23 March 2007

The Dan Land, Minmi Road, Fletcher

Staging Plan

**FIGURE 18: PROPOSED STAGING
OF DEVELOPMENT**
(Revised 18 May 2007)

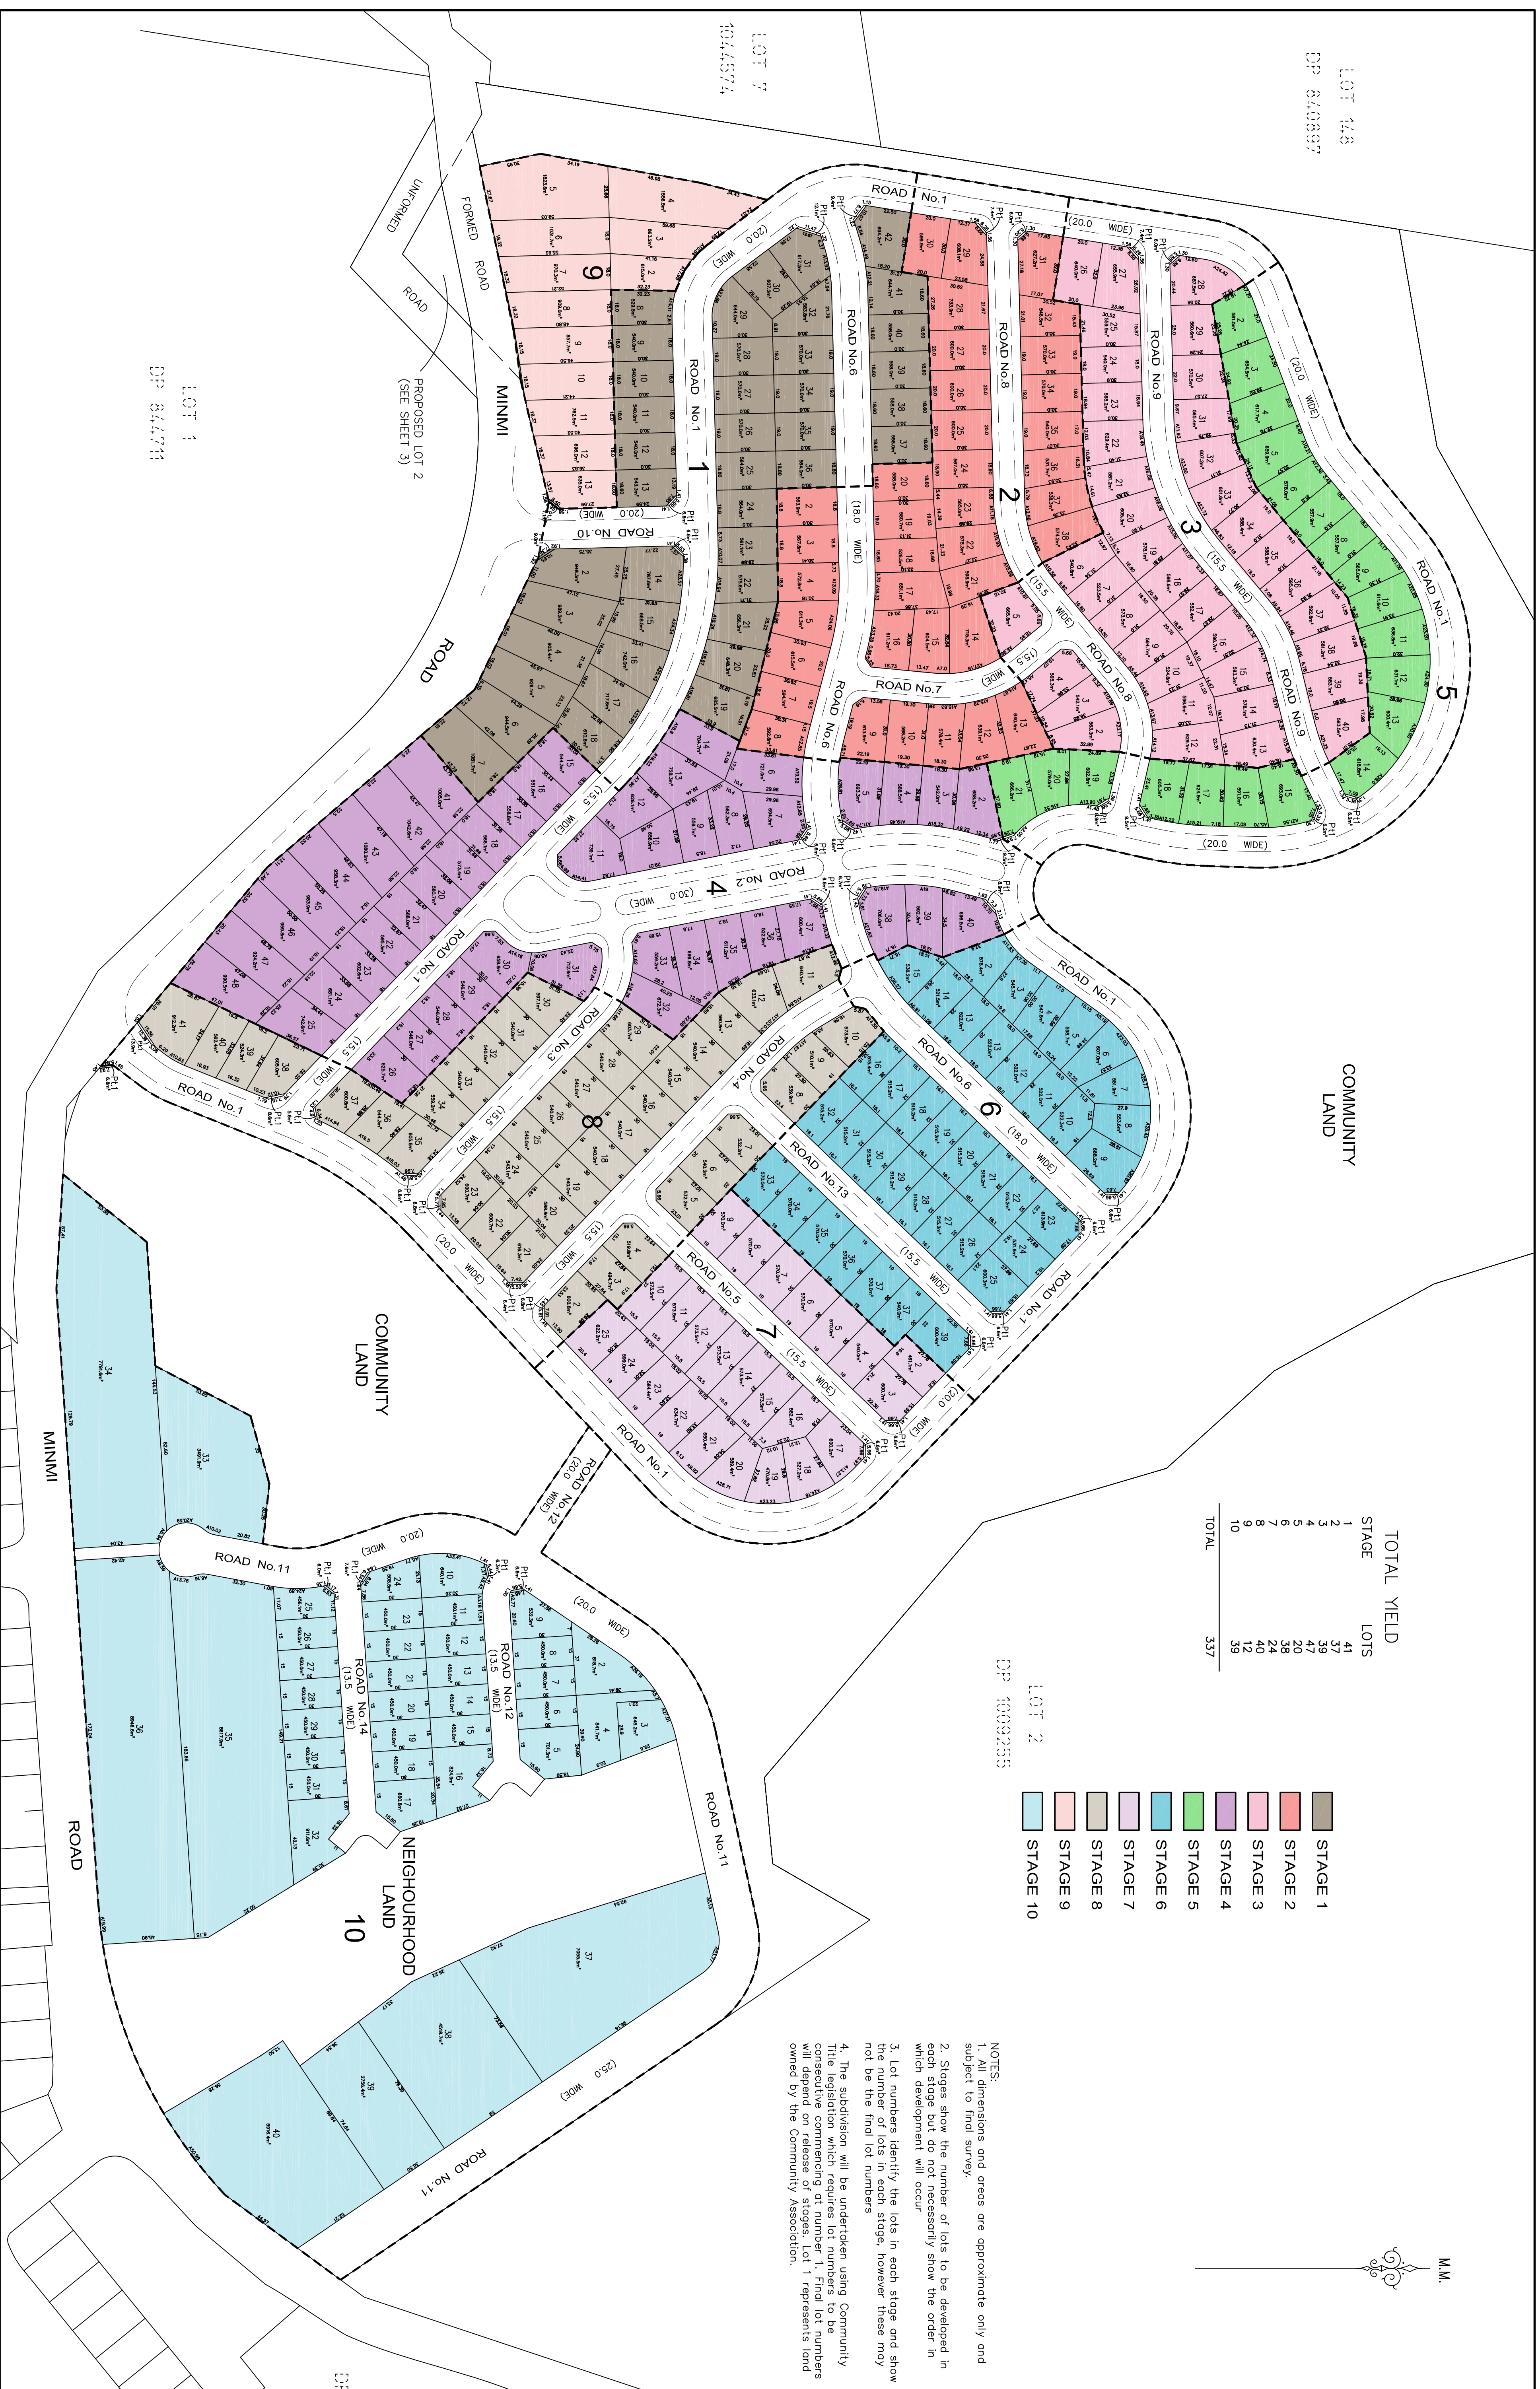
In accordance with your advice, our client wishes to formally propose an amendment to the approved staging plan, involving only an alteration to the timing of the release of the various components. These changes have principally arisen from the engineering design process which identified constraints which were not taken into account in the original staging plan. These constraints include timing issues relating to road construction (cut and fill), and water and sewer servicing. The proposed staging of the site's development is shown within the *Revised Staging Plan in support of Planning Workshop Australia's submission to DoP*, attached to this letter.
